Our ref: DOC20/1043930

Senders ref: SSD-10352

Subject: EES comments on Supplementary Response to Submissions and draft conditions for Moriah College Redevelopment – Queens Park campus – SSD-10352

Subject: EES comments on the Supplementary Response to Submissions and draft conditions for Moriah College redevelopment – Queens Park campus – SSD-10352

Figure 3 – Required vegetated buffer zone – Annexure 2 of EPBC 2002/575

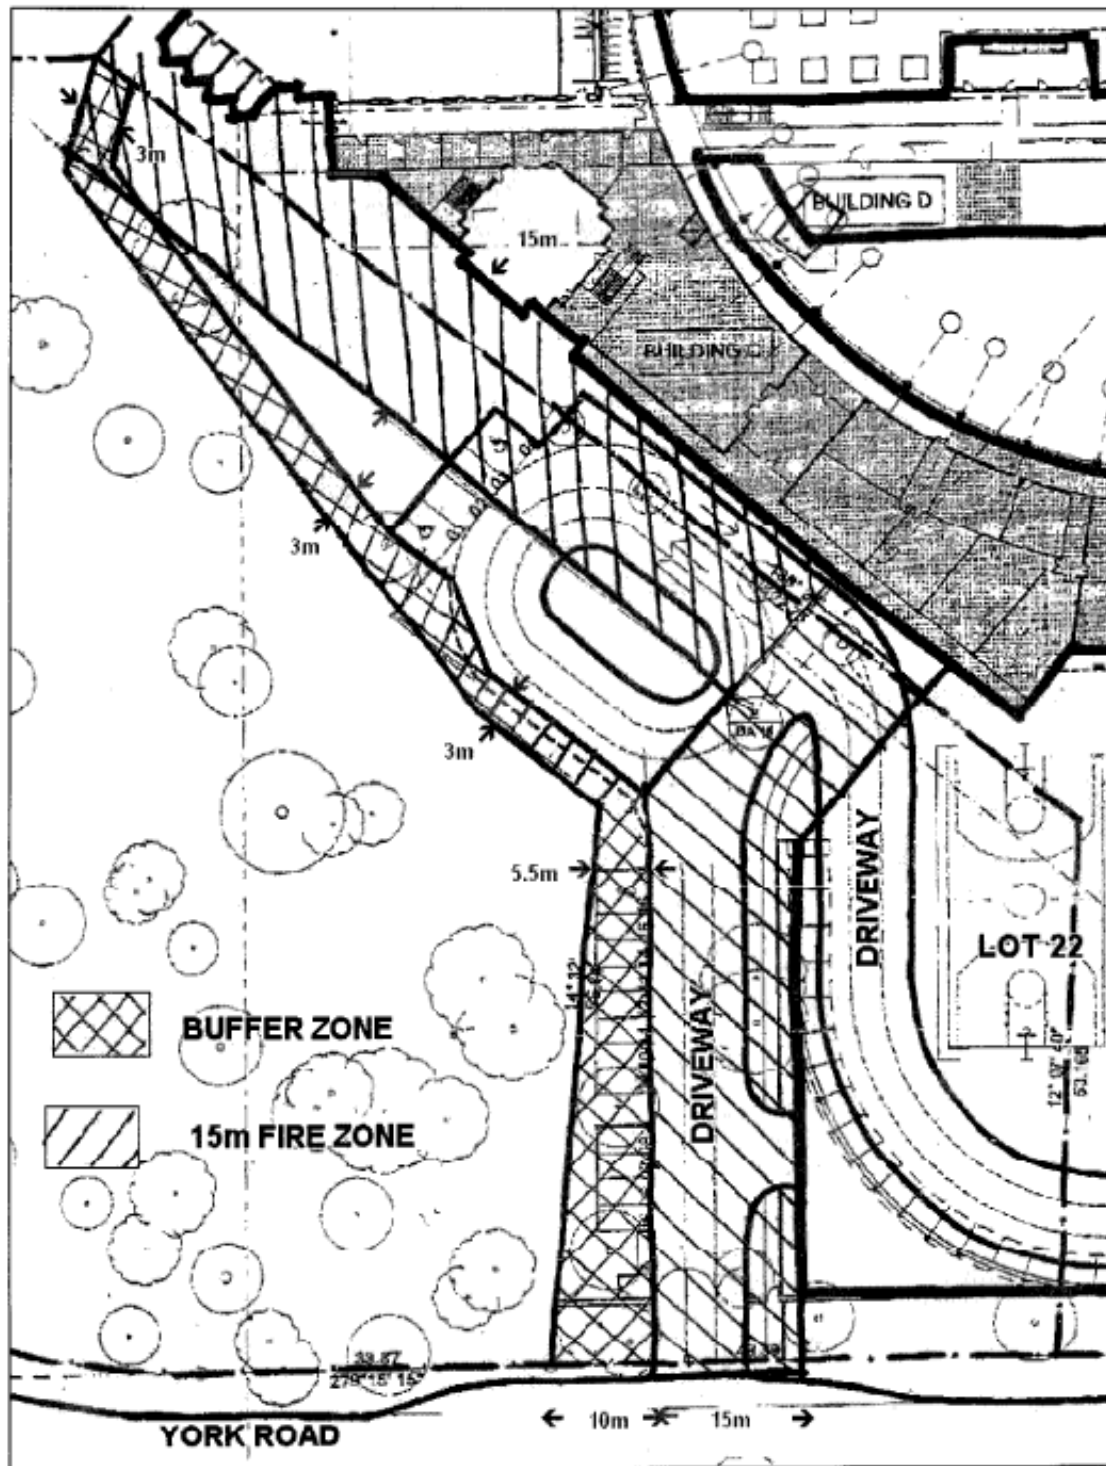
EES’s response to the RtS noted the SSD proposed the establishment of a ‘vegetation protection buffer zone’ of only one metre width within Lot 22 along its common boundary with Lot 23 to buffer the remnant Eastern Suburbs Banksia Scrub critically endangered ecological community on Lot 23, owned by the Centennial Park and Moore Park Trust (CPMPT). EES noted the proposed buffer was not consistent with, and disregarded the requirements of, a previous consent by Waverley Council (LD 282/00) and an approval by the Commonwealth Minister for the Environment (EPBC 2002/575) for development on Lot 22, which EES considered remained in force. These included

the provisions of an associated *Vegetation Management Plan for the York Road Bushland, October 2002* by Urban Bushland Management Consultants (UBM VMP) which required a buffer, of variable width but of no less than 3 metres at any point and as wide as 10 metres at its southern end. EES therefore recommended that:

- the conditions of these prior approvals apply
- the buffer zone be reinstated to the configuration, width and condition required by those prior approvals, including removal of any encroaching structures and hard surfaces
- except for works necessary to achieve the reinstatement of the buffer zone, earthworks, soil disturbance or machinery access be prohibited from the buffer zone.

EES seeks clarification as to what “needs to be resolved” means in the first dot point above.

- “The conditions of development consent LD 282/00 (granted by Waverley Council on 22 May 2001) have been partially replaced by ELC application development consents (DA-163/2017 and DA-71/2018). Nonetheless EPBC 2002/575 granted by the Commonwealth Minister for the Environment and Heritage on 25 October 2002 still applies. This needs to be resolved and works will be carried out to reinstate the buffer zone under EPBC 2002/575” (Table 7, page 30).

- “The proposal has been amended to accommodate a 3-10m landscape buffer zone along the western boundary of the site to the ESBS area located on Lot 23 in accordance with the consent conditions stipulated by LD 282/00 and EPBC 2002/575” (Table 7, page 30).

- “The amendments sought are to align the vehicular hardstand area of the proposal to accommodate a 3-10m landscape buffer zone to the ESBS area adjoining the site in accordance with the consent conditions stipulated by LD 282/00 and EPBC 2002/575” (section 2.1, page 3).

Figure 6 Amended VMP Site Plan

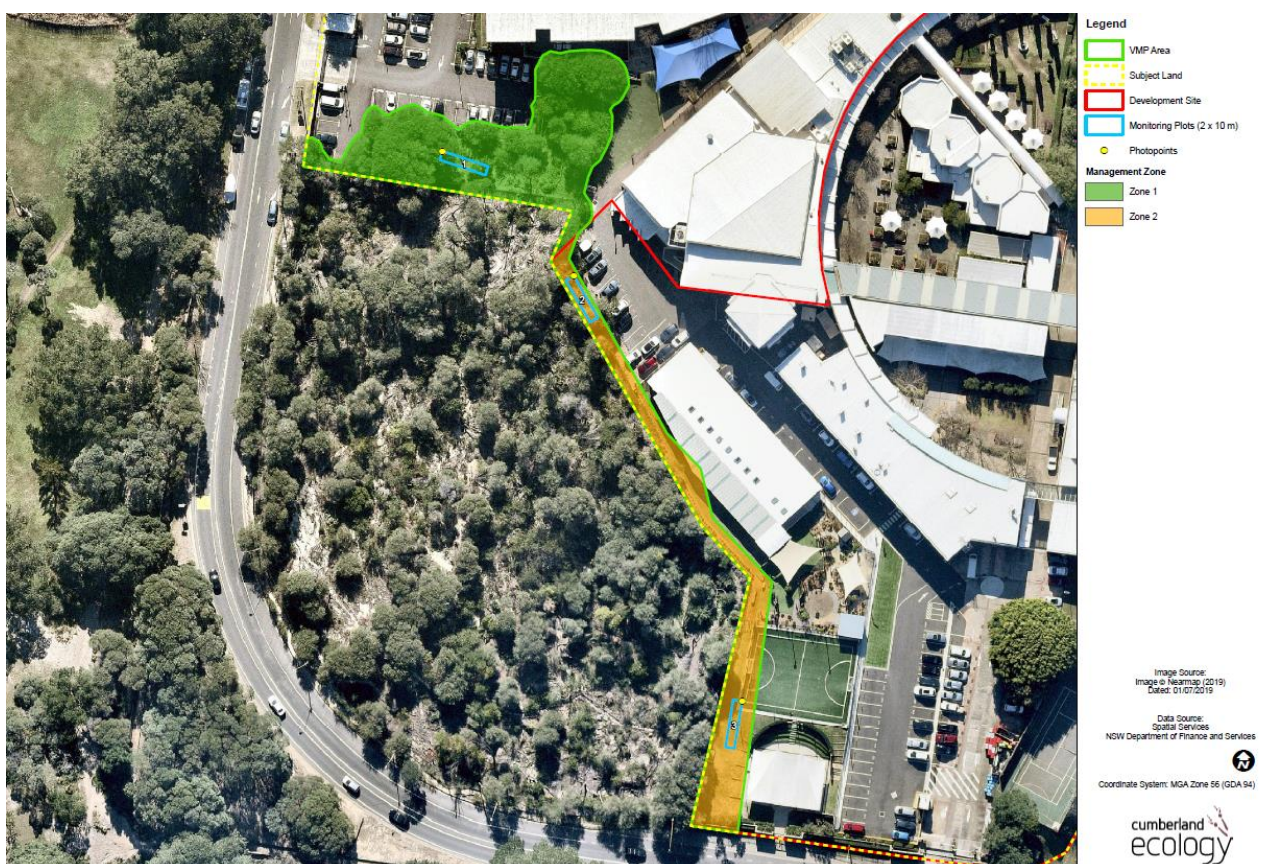
As identified above, the amended VMP makes no mention of the requirements of NSW DA 446-10-2003 or the Commonwealth approval EPBC 2004/1676 relating to protection and conservation of existing remnant ESBS on Lot 1 DP 701512, i.e. within Zone 1 of the VMP.

The VMP indicates that no revegetation is proposed within Zone 1 (i.e. the existing ESBS of the VMP Area). Revegetation practices are proposed only for the Zone 2 buffer area with ESBS species (section 6.1, page 17) and it is to proposed revegetate the ground and shrub layers of Zone 2 (section 7.2) using the planting of seedlings propagated from locally sourced plant material (section 7.3). However, “revegetation” is being used in the narrow sense of ‘planting or seed introduction’ only. Other bush regeneration practices apply to both management zones, such as the “removal of all exotic vegetation” and “rehabilitation actions ...that will support enhanced diversity of the remnant ESBS including periodic weeding practises and promotion of natural regeneration” (section 4.1.1.1, page 12). These also should be undertaken by suitably qualified bush regenerators.

Consequently, EES considers that where the VMP applies, any proposed works within the VMP Area, including bush regeneration works (including weed removal, rehabilitation works, or revegetation) and landscaping, should be undertaken by a suitably qualified bush regenerator with experience in restoring and maintaining the Eastern Suburbs Banksia Scrub in the Sydney Basin Bioregion (ESBS) ecological community. EES therefore recommends that if the SSD is approved proposed condition of consent G29 is amended to the following:
